23 Ocean Avenue plat

I would just ask for three minor items. Survey review plan markup attached.

Ocean Ave No 23 Site Subdivision Plat 9 14 2016 Survey Review 9 23 2016.PDF

SITE/SUBDIVISION PLAN (PRELIMINARY)
OF 23 OCEAN AVENUE
PORTLAND, MAINE
FOR RECORD OWNERS:
STEVEN E. AND ROBERTA S. COPE
P.O. BOX 1398
PORTLAND, MAINE 04104

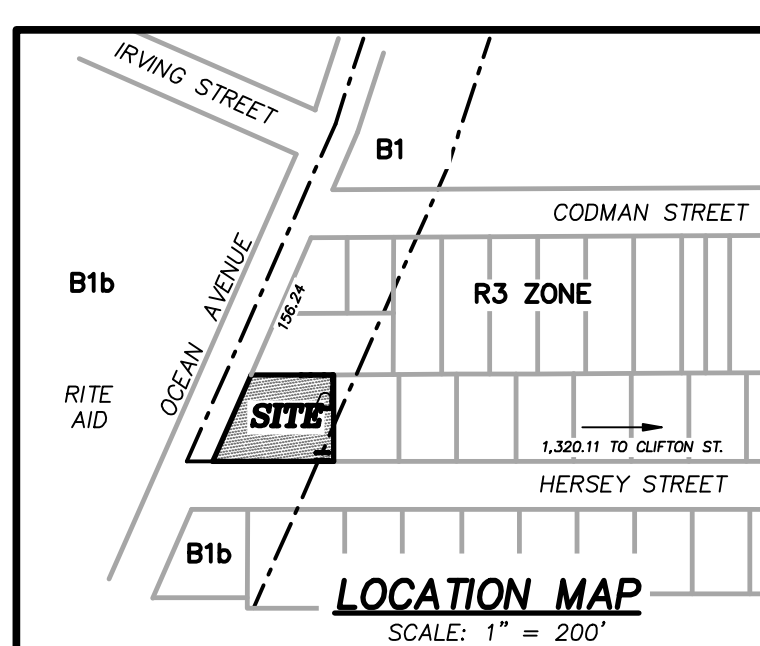
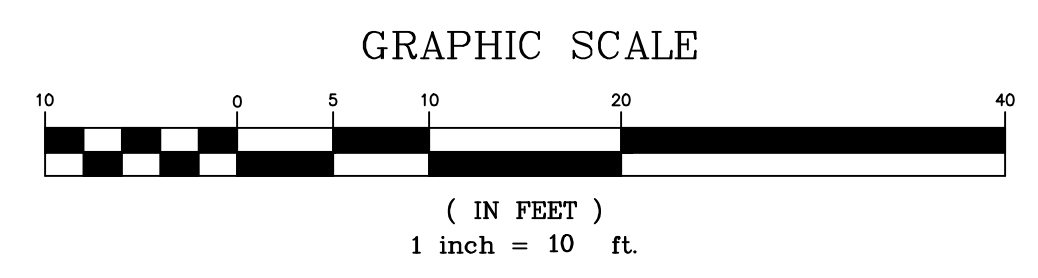
1. Add chord bearing and distance for the proposed pedestrian easement detail.
2. Add text "Proposed" before "Pedestrian Easement".
3. Possibly add height clearance for the one foot wide aerial easements along Ocean Ave and Hersey St.
